From: Martyn White
To: Richard Castro-Parker <Richard.Castro-Parker@arun.gov.uk>
Subject: EP/179/18/PL

EP/179/18/PL

I note that the application relates to the demolition of an existing house and the erection of a terrace of three houses. I also note that revised plans have been submitted to the council. These comments relate to these revised plans.

Drawing: Street scene

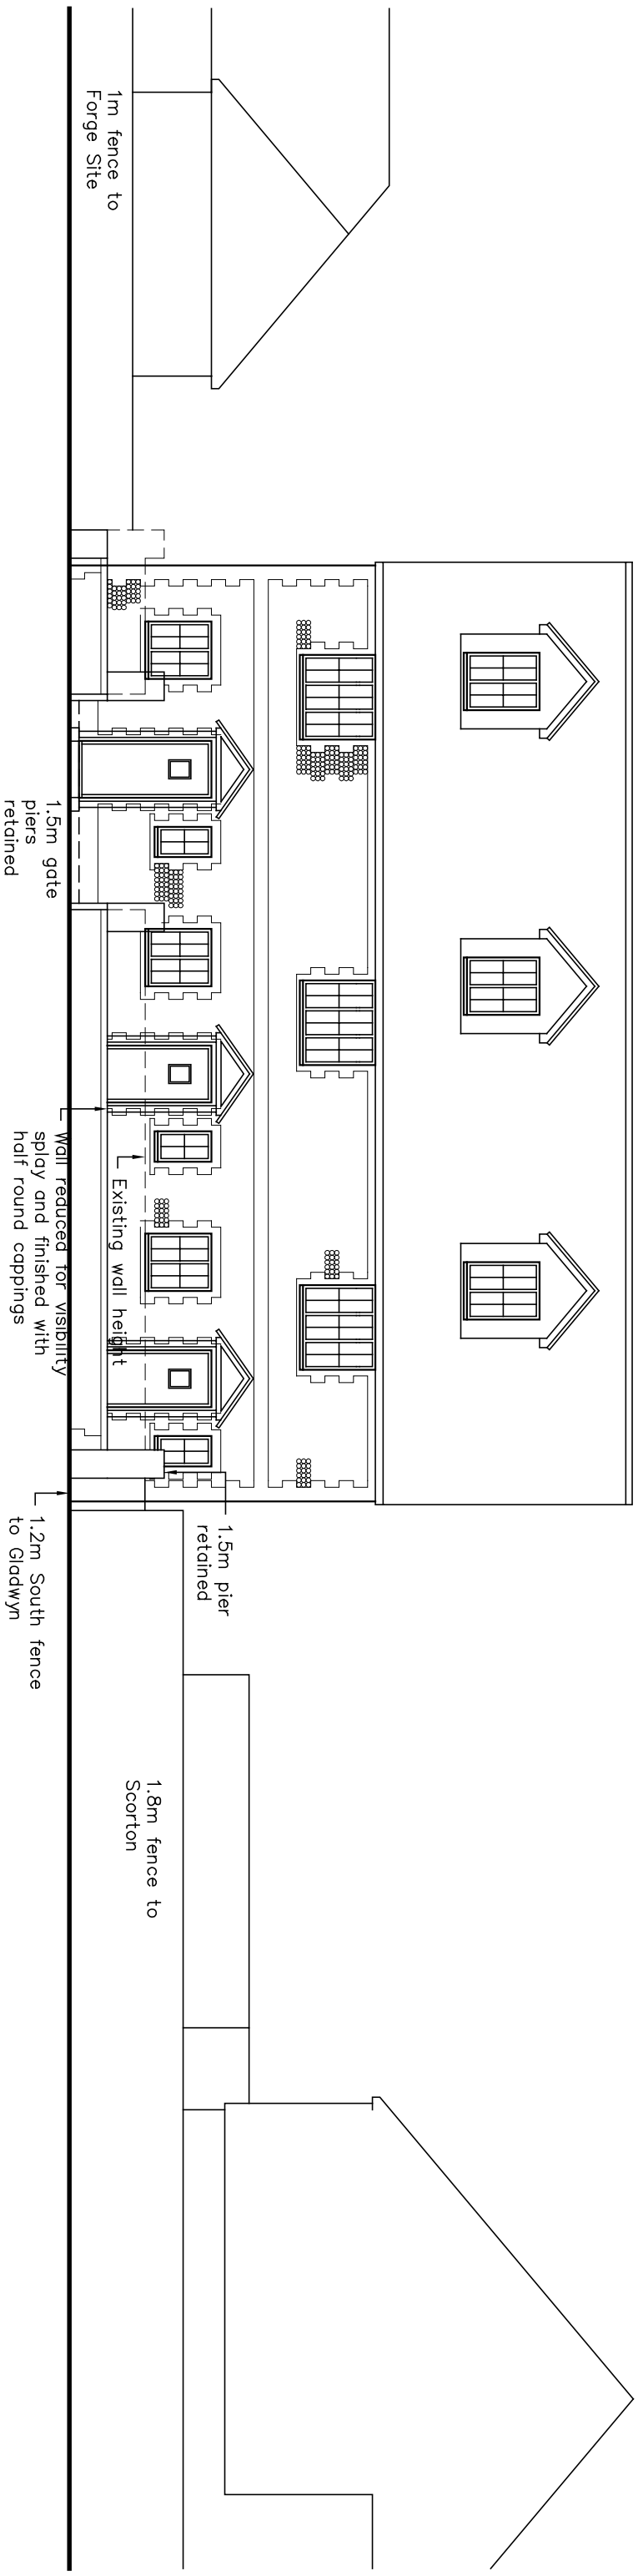
The revised proposals appear to consider the nearby heritage assets and take clues from their appearance. This manifest itself in the form of an entire elevation of flint, improved fenestration/joinery details and improved materials.

The reduction in the height of the wall is unfortunate, and it would be better if it were to remain at its existing height. However, it is stated that this is a requirement of the highway authority, for reasons of safety. As a

consequence, it is deemed to be acceptable in this particular instance. It is requested that all material removed from the wall is removed and used as part of the development. This could be dealt with by way of condition.
